Subject: FW: AB/120/20/PL and AB/ 121/20/L Old Bank House, 1 High Street, Arundel

Subject: AB/120/20/PL and AB/ 121/20/L Old Bank House, 1 High Street, Arundel

Project:- Old Bank House 1 High Street Arundel West Sussex			
Title:- Proposed Floor Plans			
Client:- Moor Construction Ltd			
Scale:- 1:50 (@A1)			
Drawn By:- PJD	Checked By:-		
Date:- 10/11/20	Date:-		
Job.No:- 200042	Drg.No:-	Rev:- 06

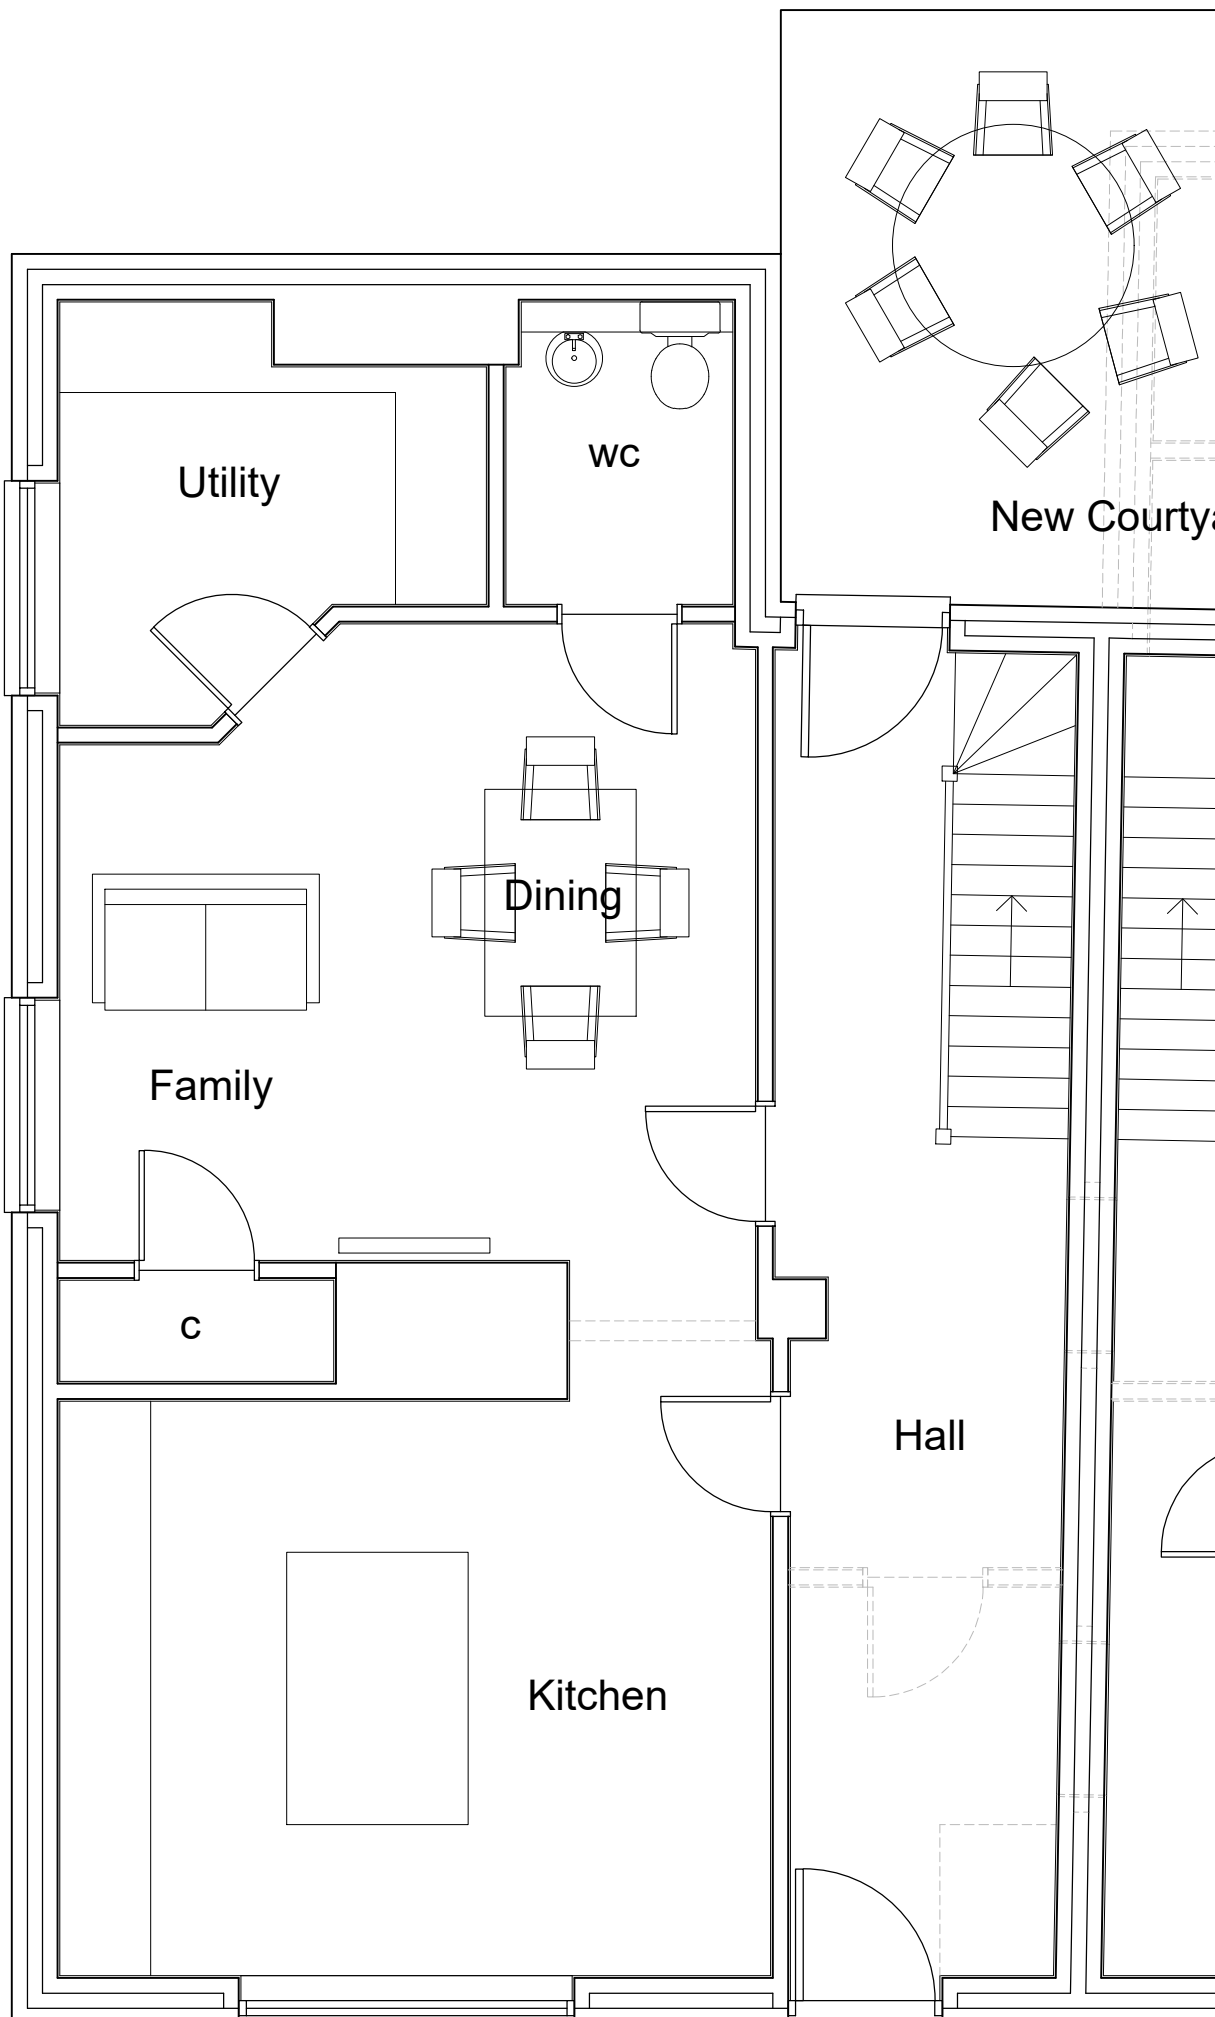
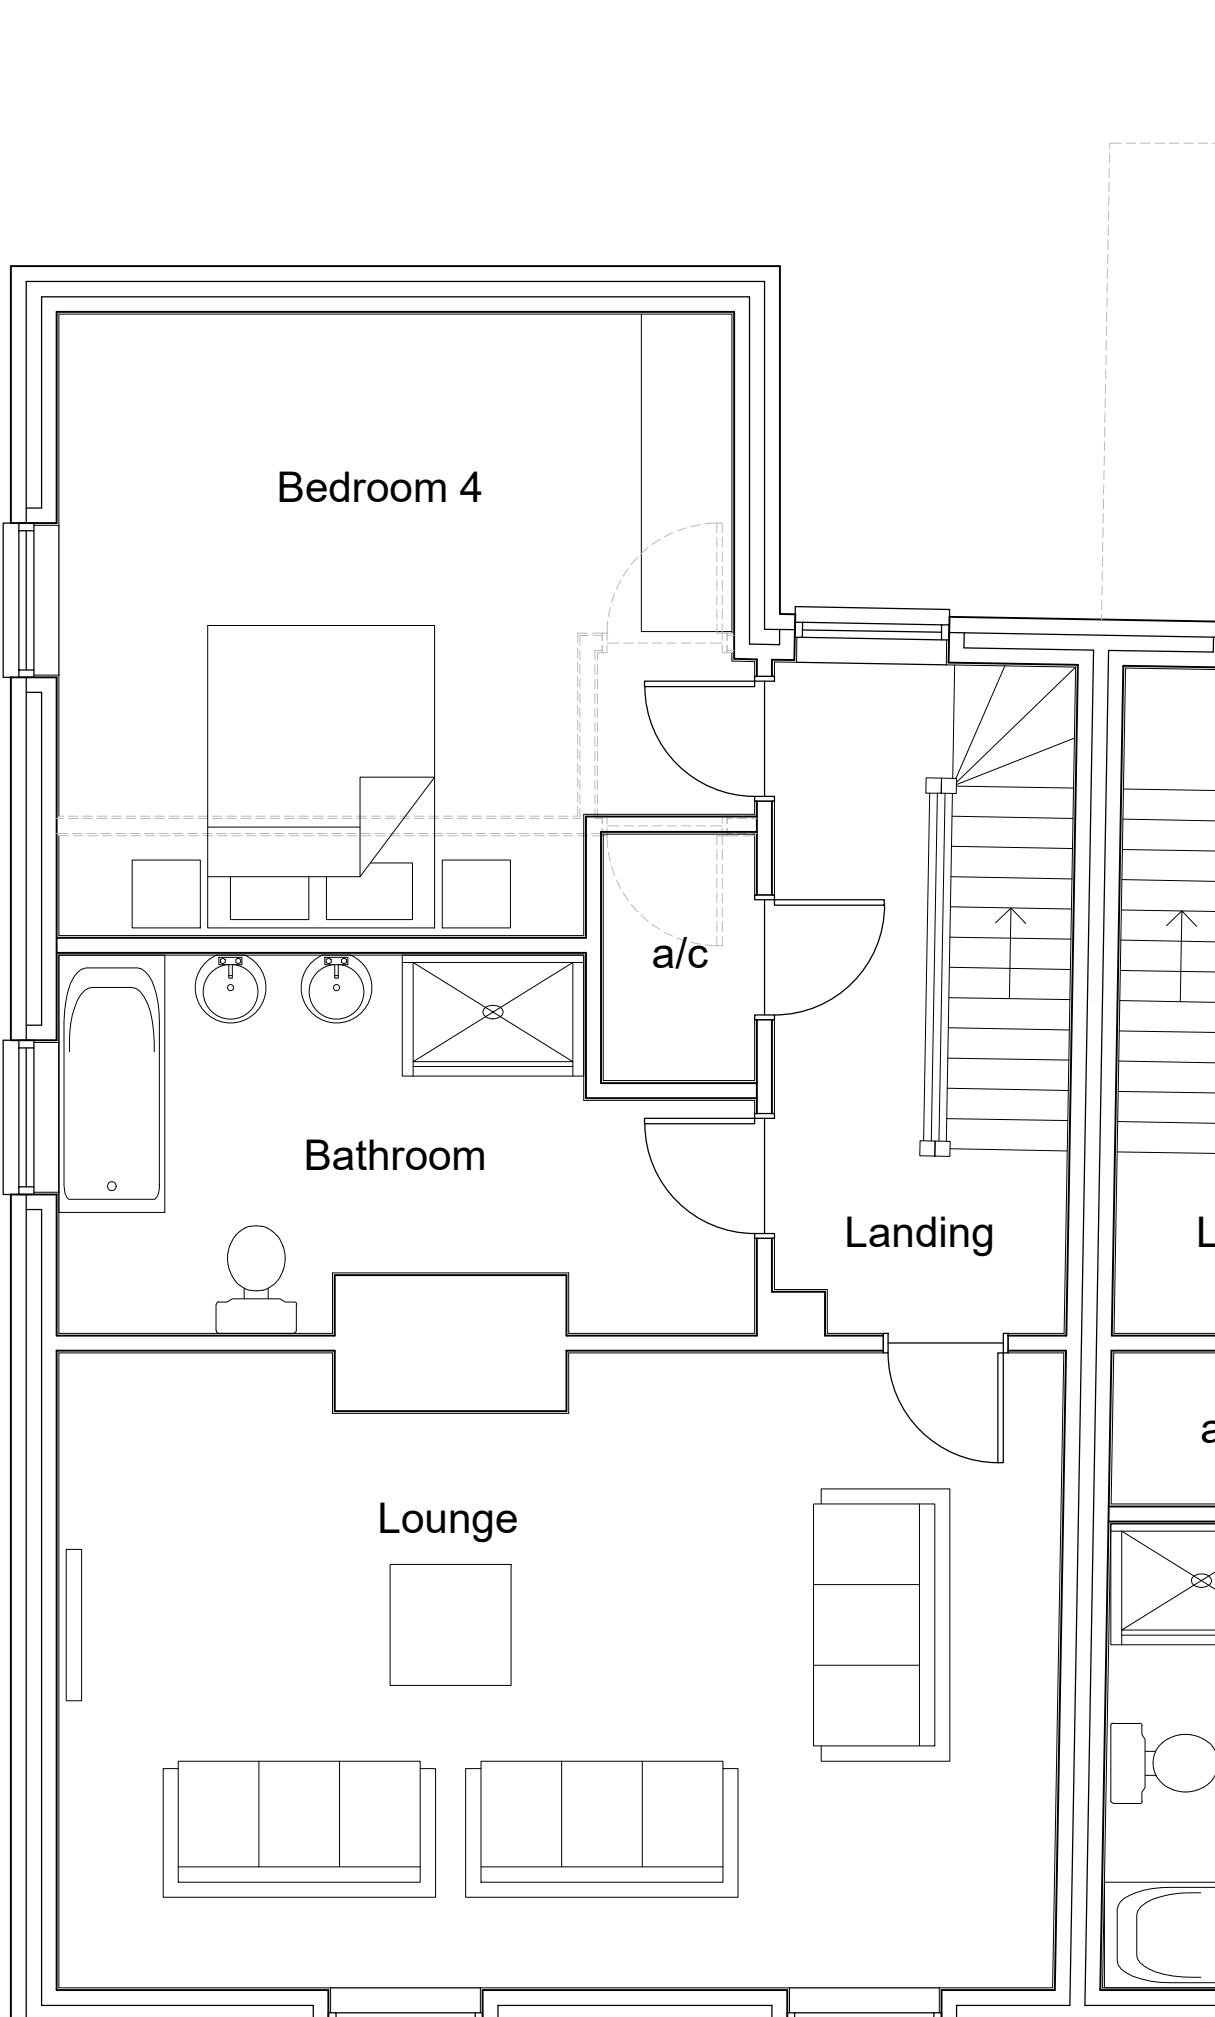
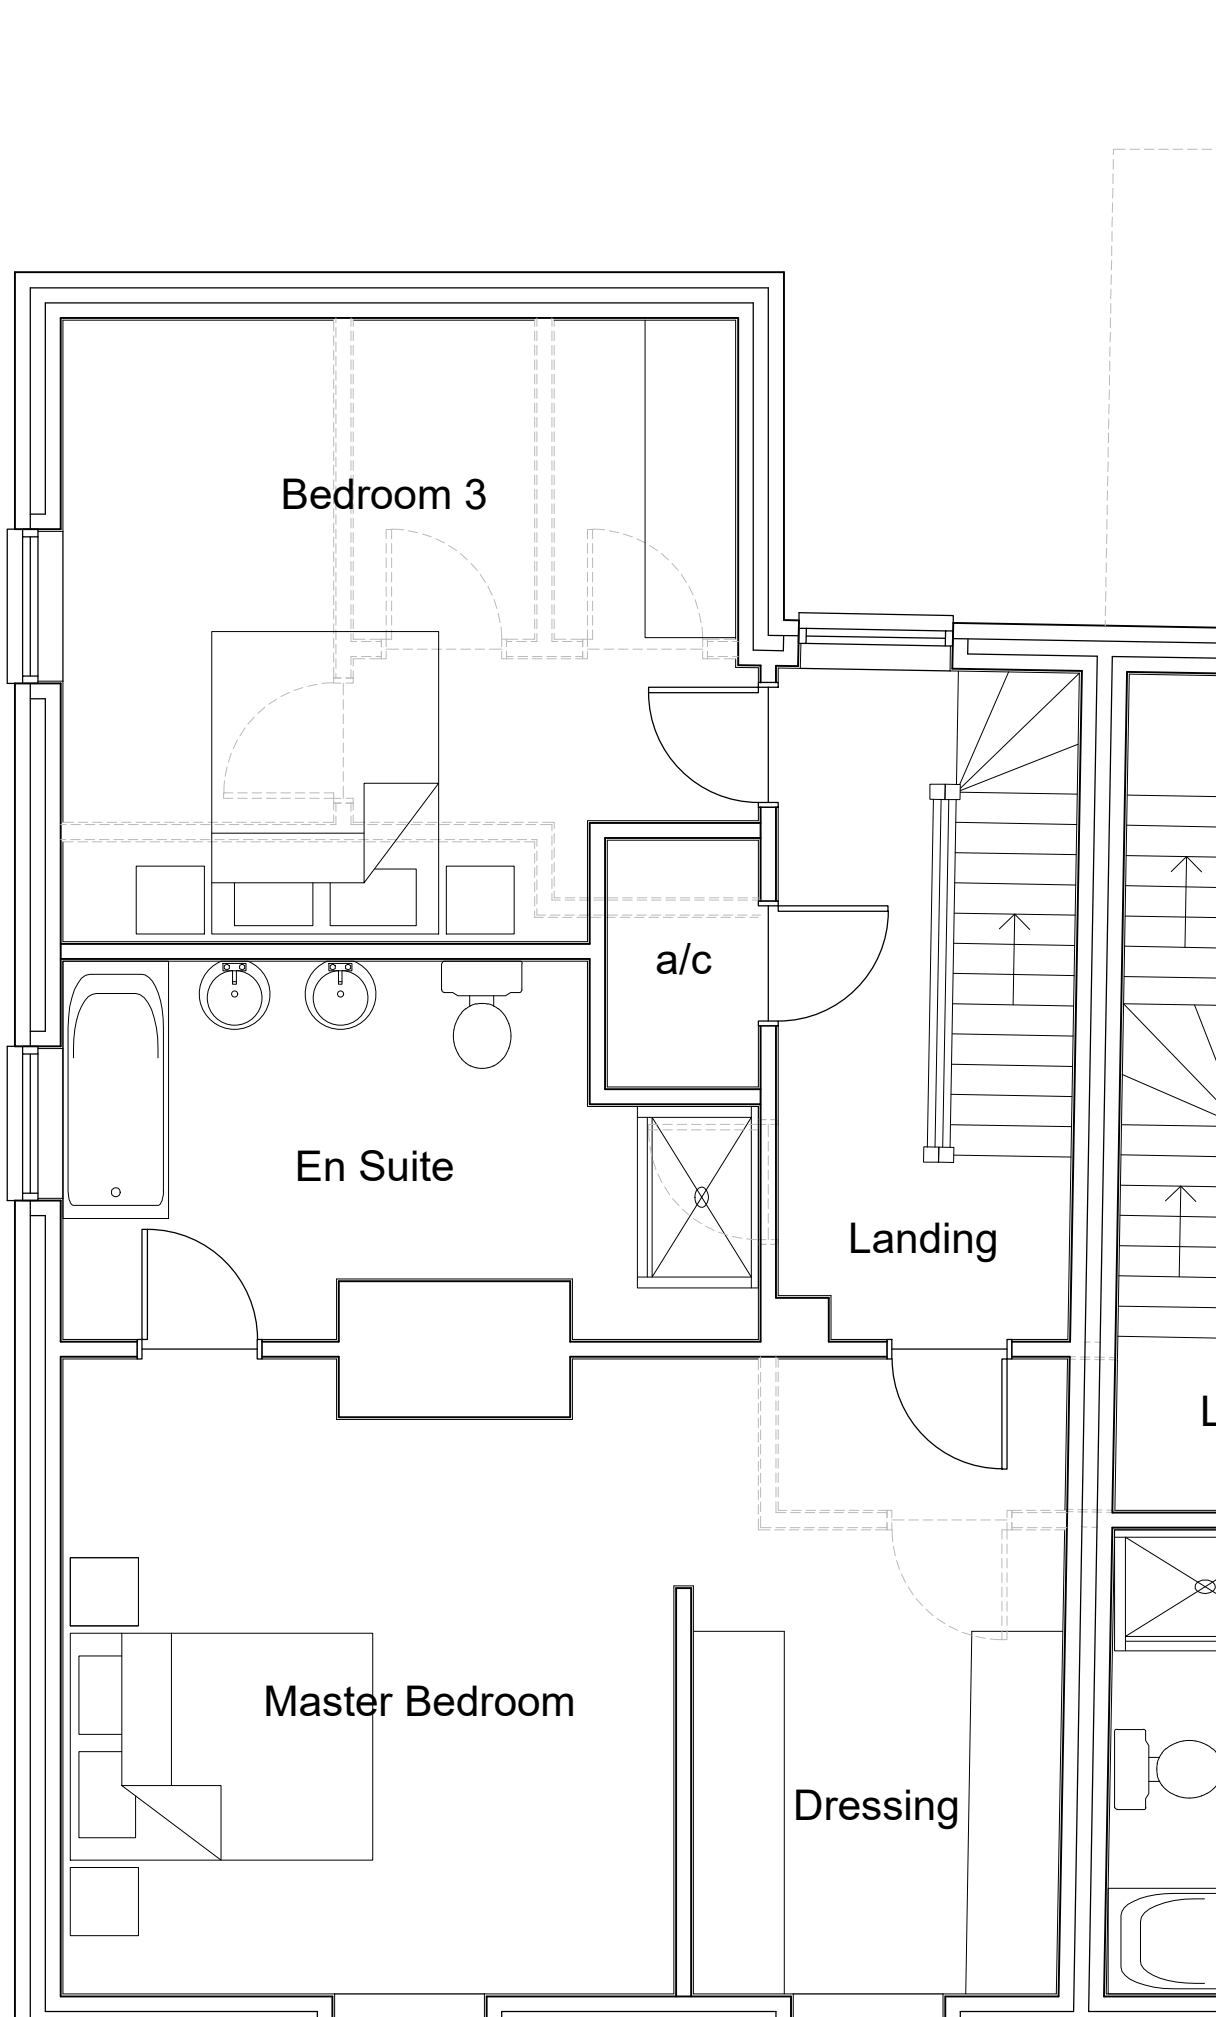
I have been looking at your applications with a view to writing my reports prior to the Christmas break, but I don't think it is going to be possible given the discrepancies in the location/block and floor plans. There is no plan clearly denoting the extent of the rear outside amenity area and the red edge of the application site to the rear of the premises does not appear to tally with the ground floor plan. The shape and projection to the rear do not appear to correlate. Please can you clarify and let me have revised as soon as possible.
